# PART B

**Assessment of project changes and response to submissions**

## 4 Environmental Assessment – general submission issues

= Cream Puff Road

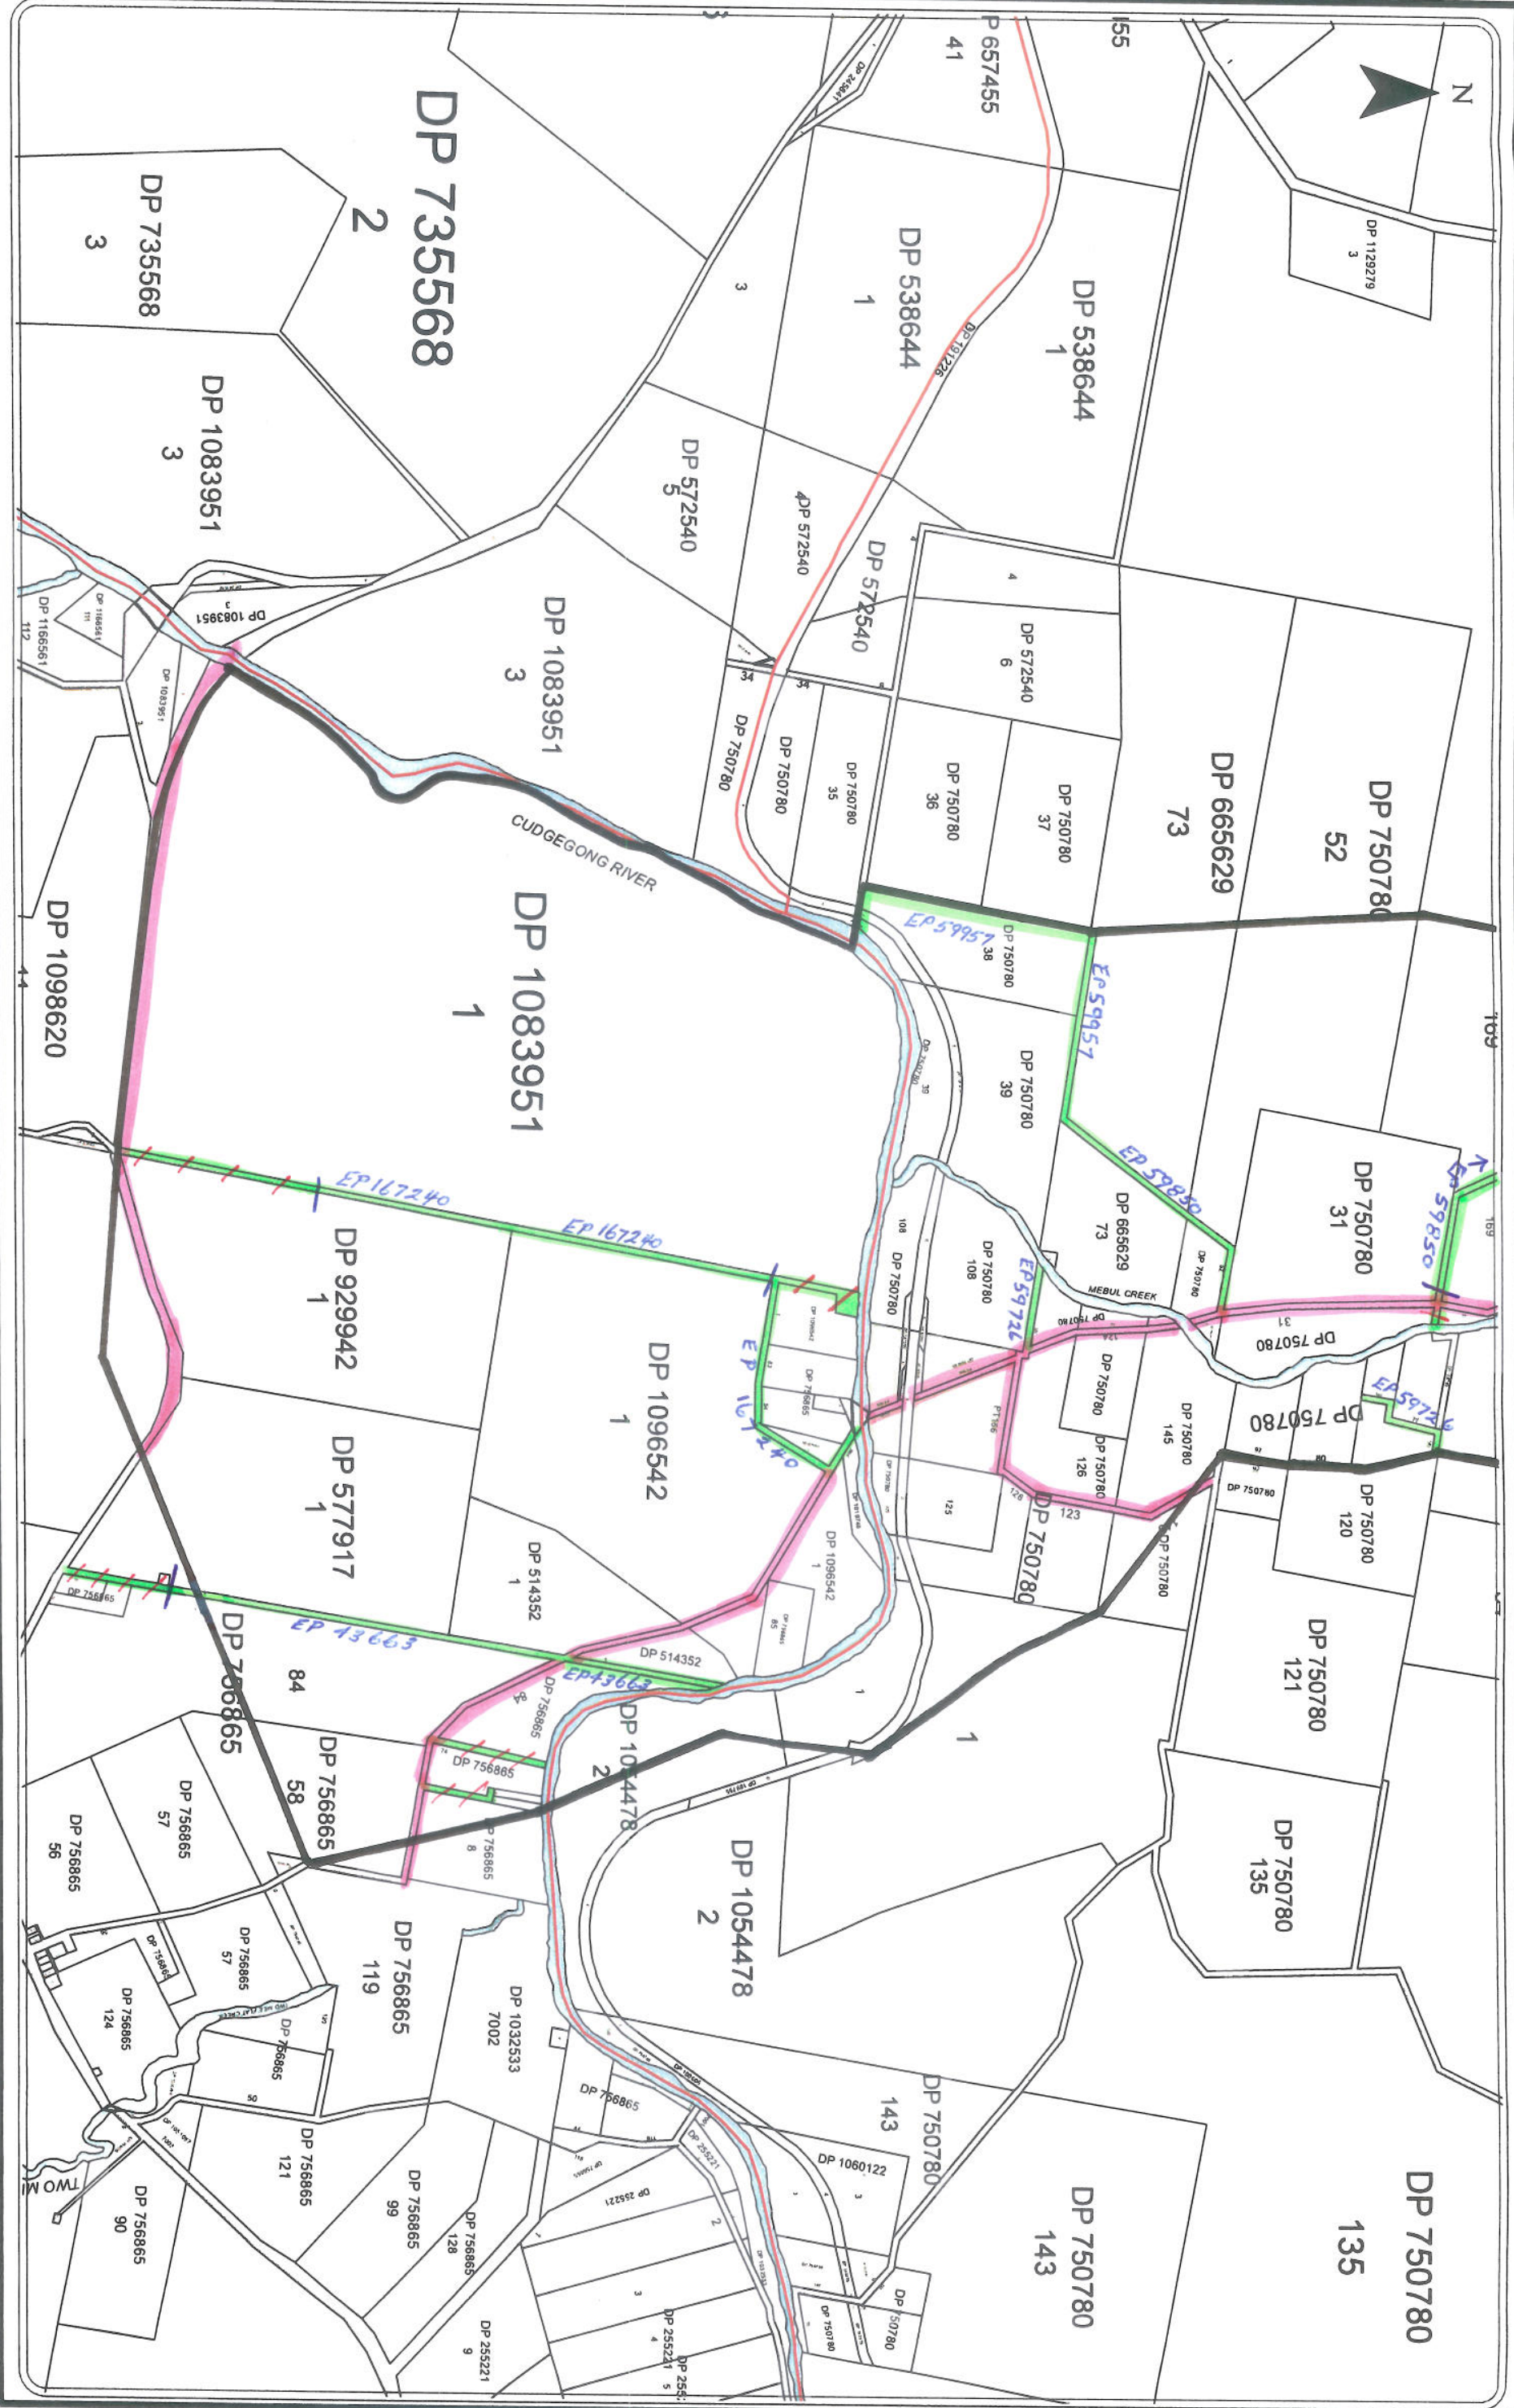
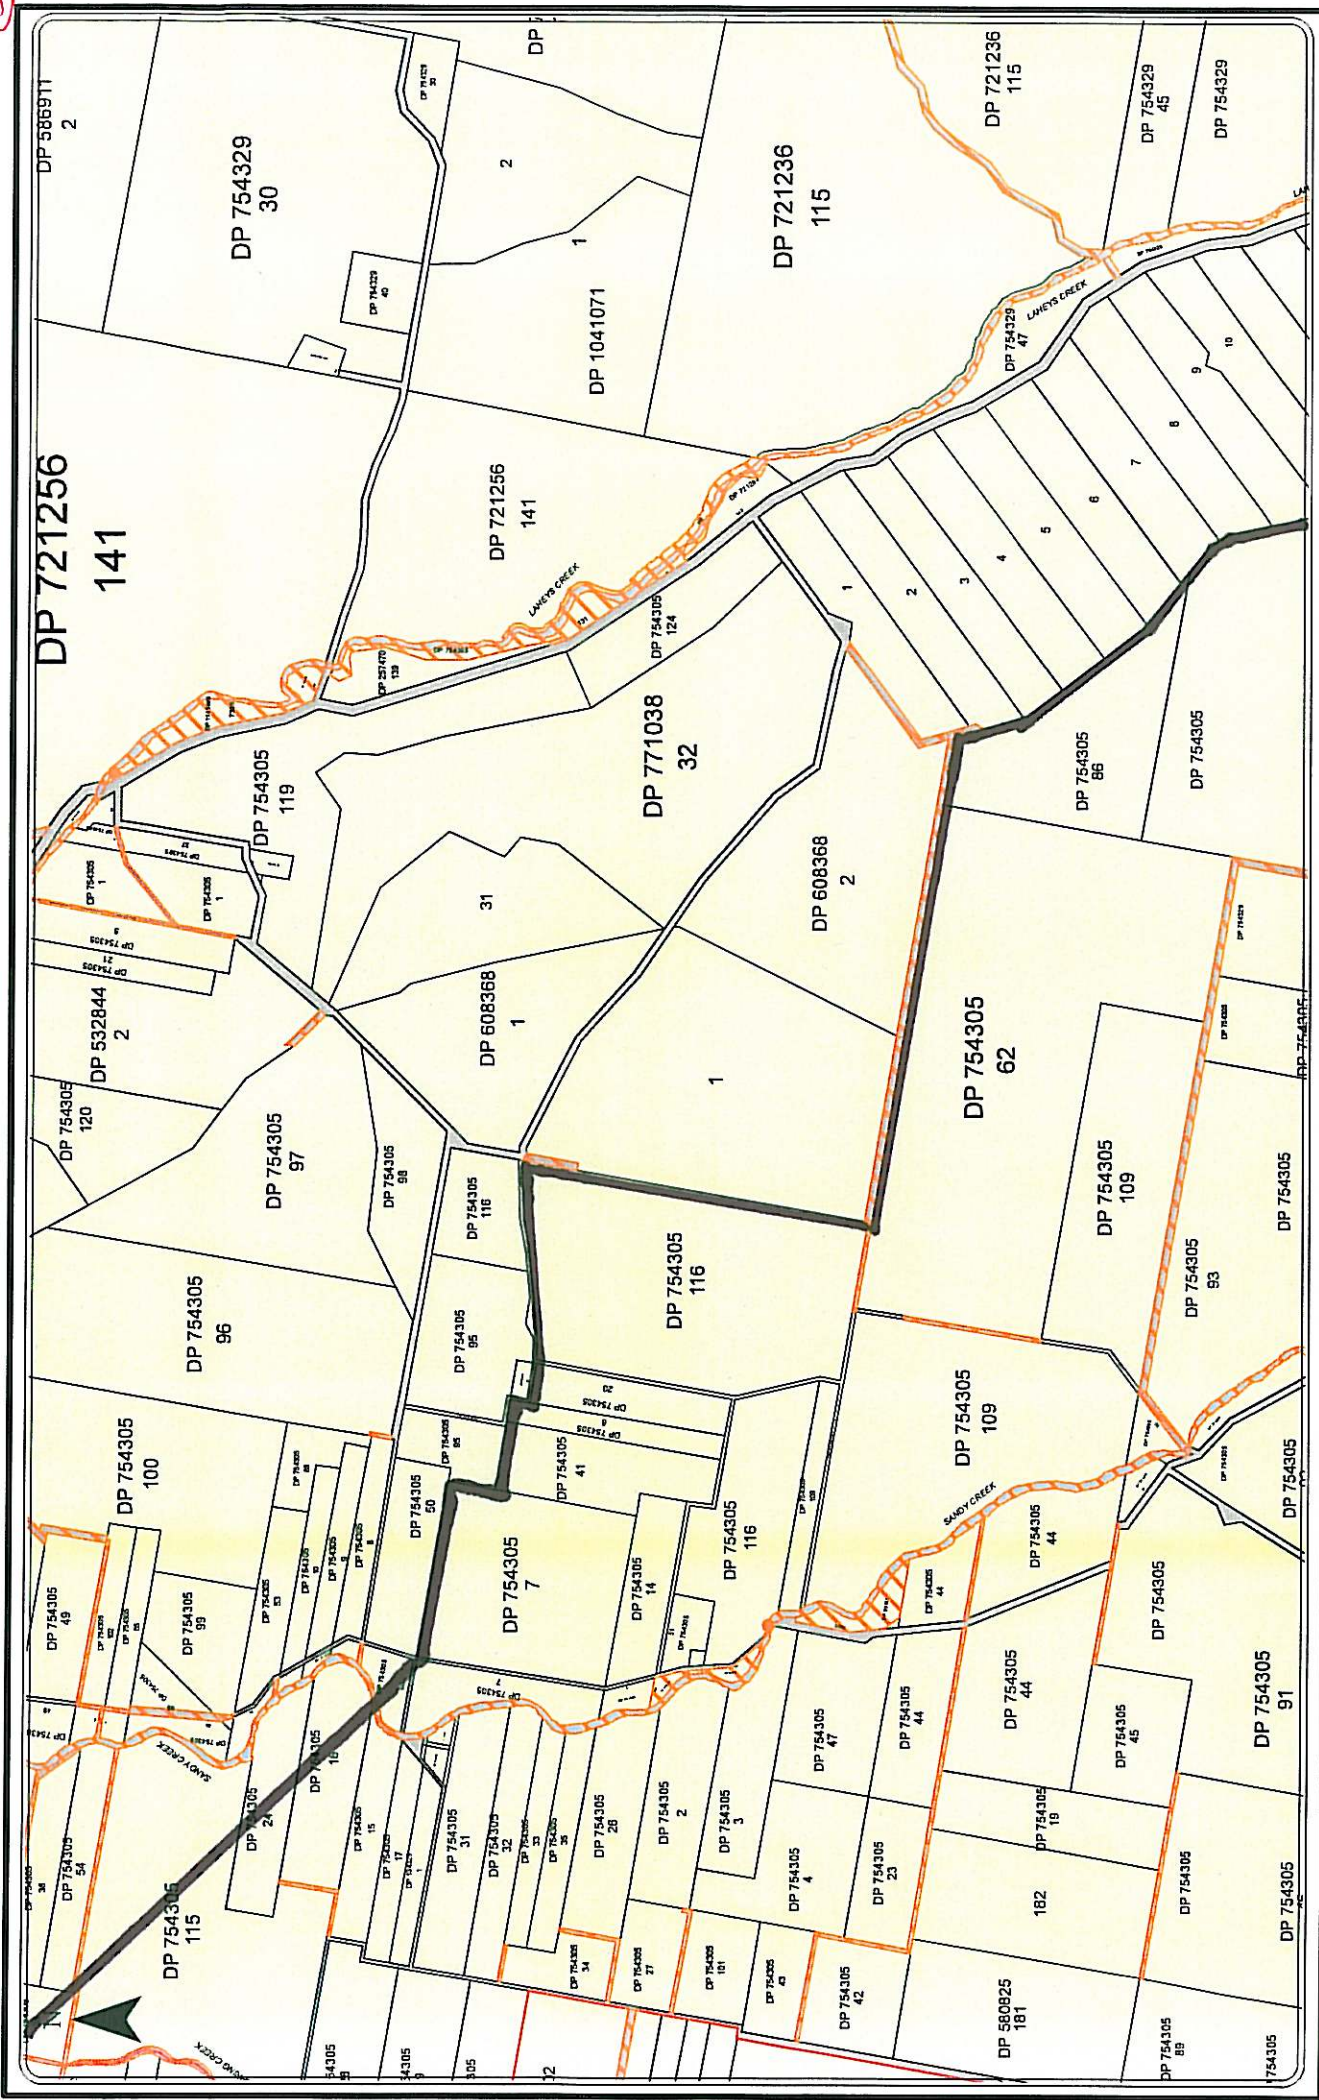
Crown Lands (part of the DPI) comments there are a number of Crown (and council) roads located within the mining area and the proponent will need to make applications to close and purchase these roads before any mining works begin. Contact should be made with the Catchments and Lands Division (Crown Lands) for further details and to determine appropriate actions. Crown Lands goes on to comment that there are a number of areas of Crown land as well as a large number of Crown (and council) roads within the Project Application Area (but located outside the mining area). The proponent will need to contact the Catchments & Lands Division (Crown Lands) to obtain the necessary approvals to occupy Crown land and/or to determine appropriate actions to allow any Crown roads to be used for ingress and egress from the mining area.

CHC will apply to buy and close the required Crown and council roads and for ongoing access to Crown land. An updated map of Crown land is provided in Appendix D. CHC does not object to the conditions proposed by Crown Lands but notes that draft project approval conditions are prepared by the DP&I and final project approval conditions are prepared by the PAC where the commission is the determining authority as will be the case for the Project.
